Application No.	2021/90605
Proposed Development:	Erection of an industrial building (B1(c) use)
Location:	land at, Vanguard Processing Equipment, Spa Fields Industrial Estate, Slaithwaite, Huddersfield, HD7 5BB
OS Map Reference	SE 408622.5201 414284.1785
Applicant/Agent:	Farrar Bamforth Associates
Class:	Small Major Developments

**Consultation Response from KC,
Highways Development Management**

**2021/90605 land at, Vanguard Processing Equipment, Spa Fields Industrial Estate, Slaithwaite,
Huddersfield, HD7 5BB**

Erection of an industrial building (B1(c) use)

GA Site Layout Plan

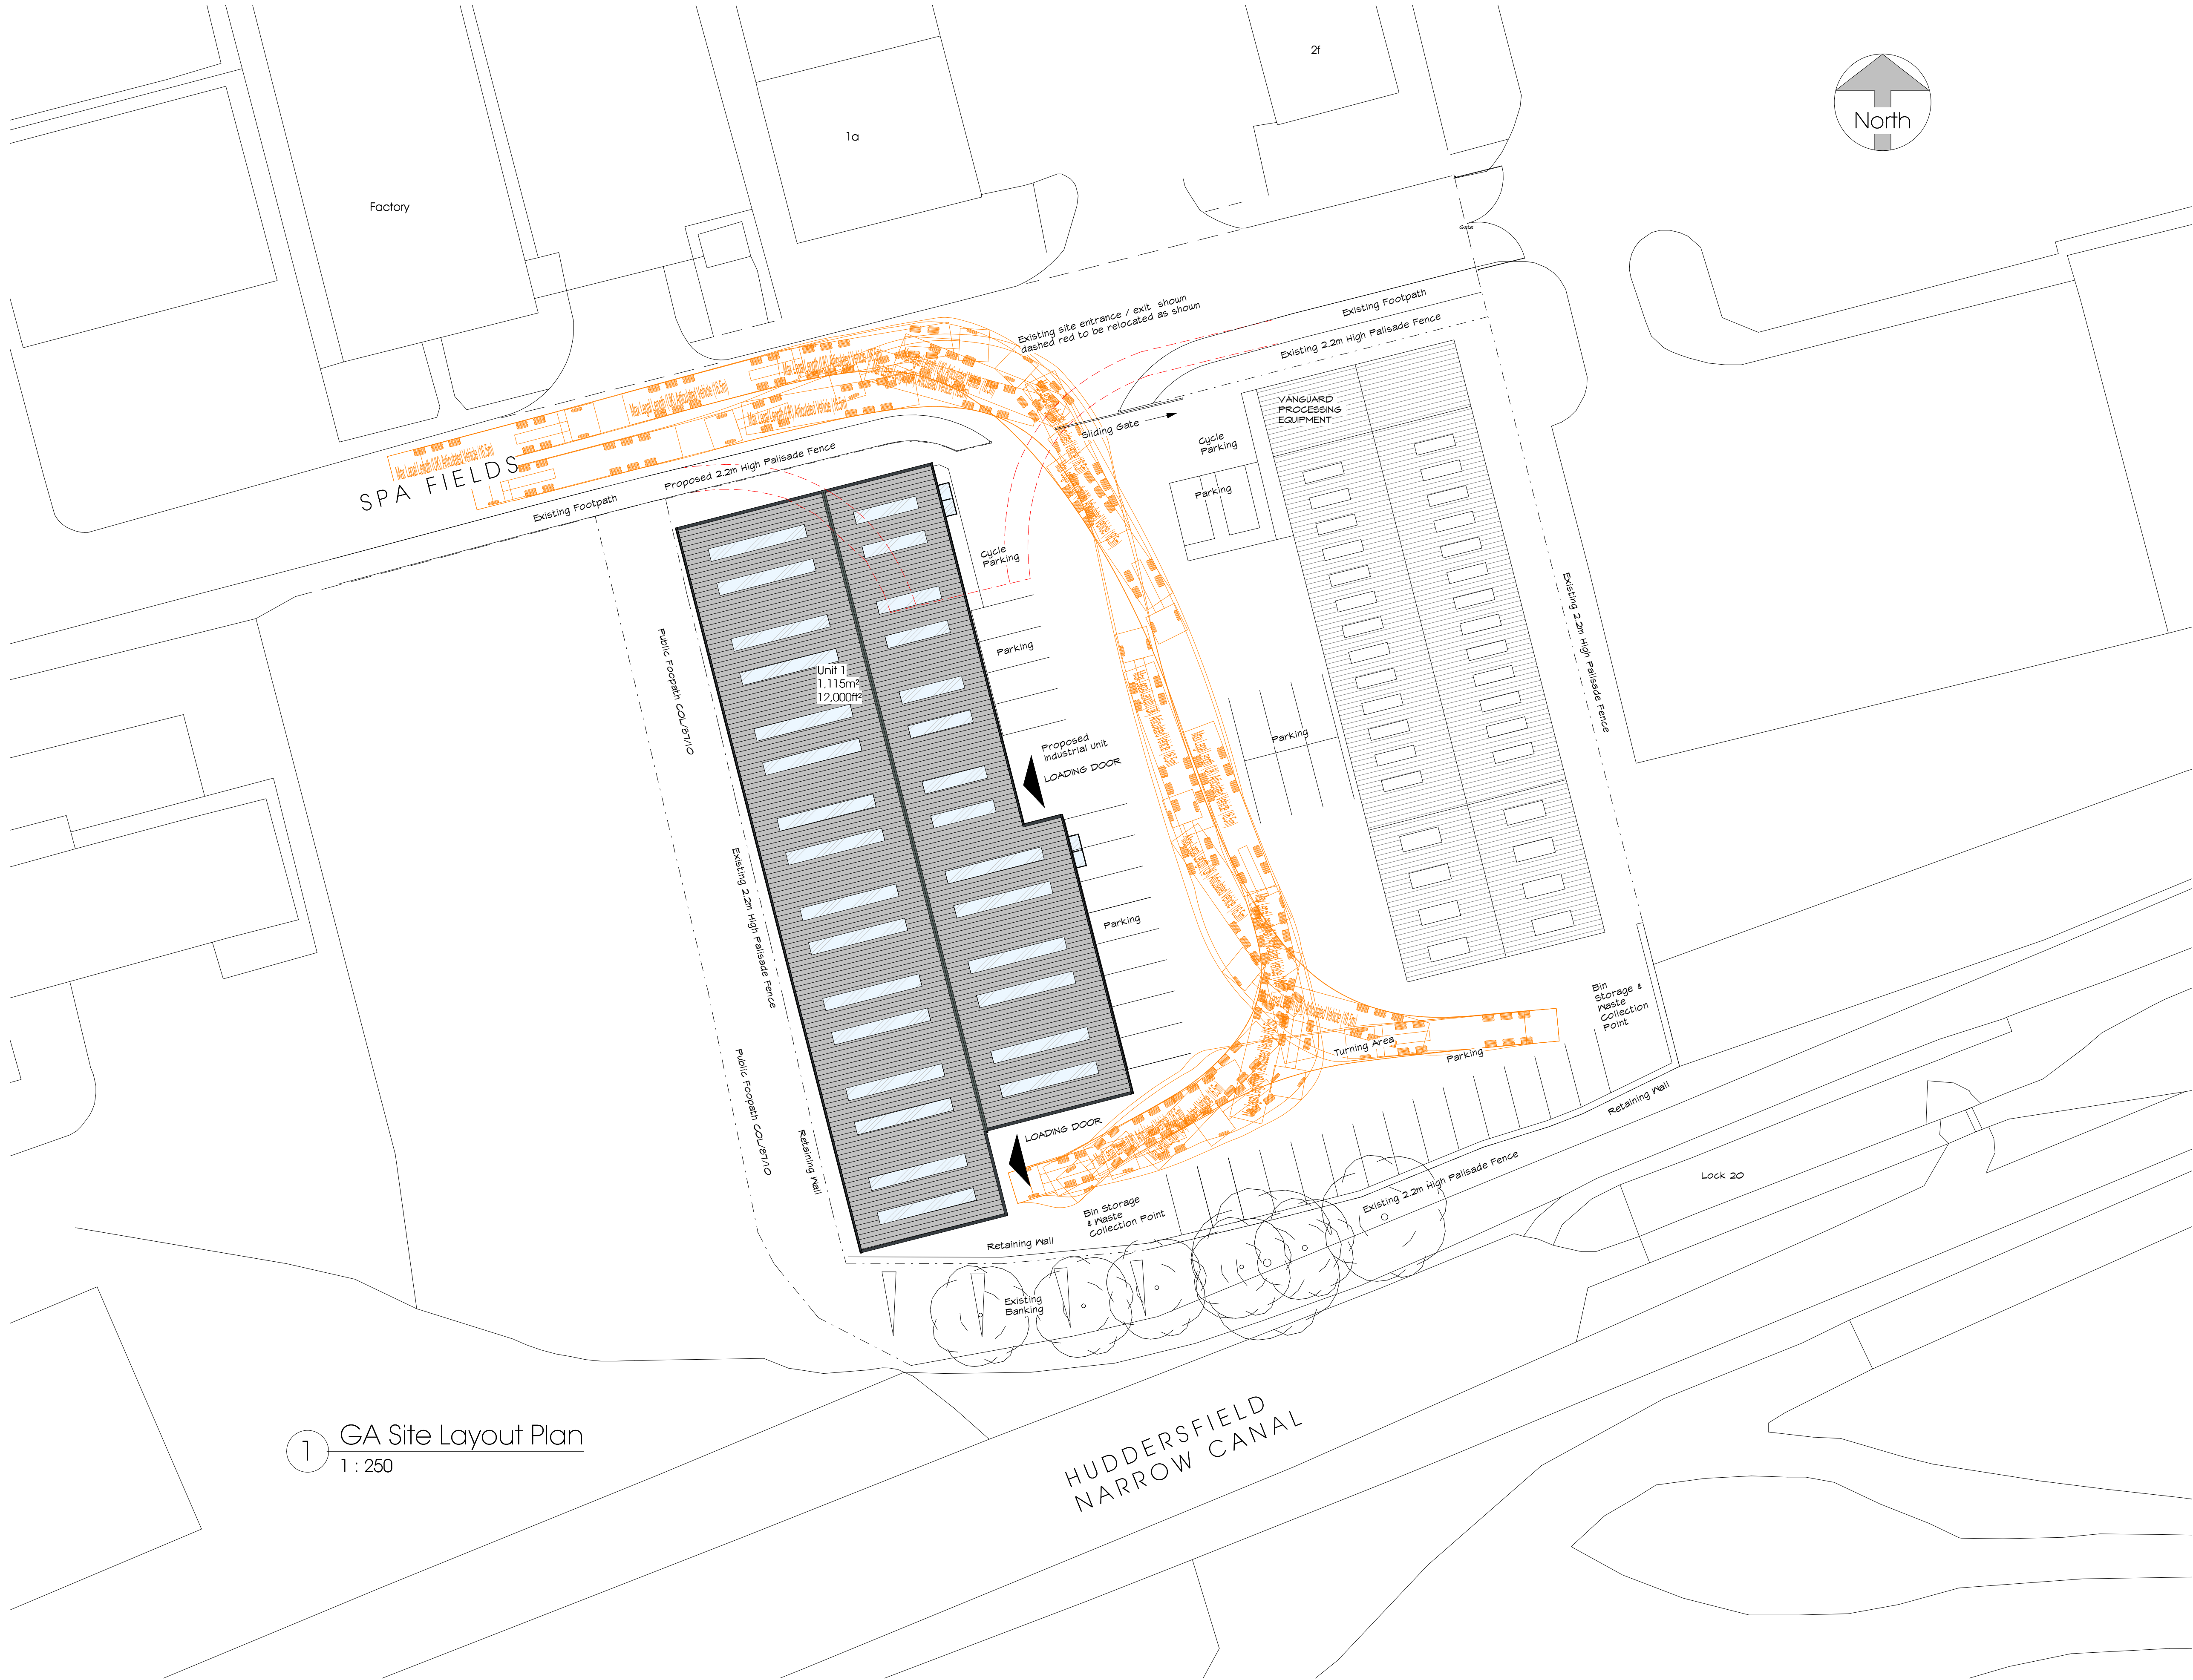
The proposed position of the new industrial building is in the location previously approved under planning application number 2016/92825. The entrance is shown to be set further forward and wider than the previous layout with a single sliding gate shown to be provided.

To facilitate the positioning of the proposed building, the existing site entrance/exit is to be relocated centrally within the site frontage. These proposals result in the loss of the existing turning head to Spa Fields which is not considered acceptable.

Swept path are shown on the site layout plan to show that a pantechnicon can access the site from Spa Fields and turn within the site.

- 1, The turning head at the end Spa Fields is part of the public highway and HDM would object to the loss of this existing turning facility. Whilst HDM have no objection to the turning heads being re-positioned it must be retained as a turning facility to Spa Fields.
- 2, The swept paths should be for a 16.5 metre articulated lorry and not only a Pantechnicon.
3. Where gates are proposed they should be set back a minimum of 16.5m from the adopted highway boundary to allow commercial vehicles to pull off the highway.
- 4, No details of any proposals for the storage and collection of wastes are provided.

the proposed removal of the existing turning head to Spa Fields.
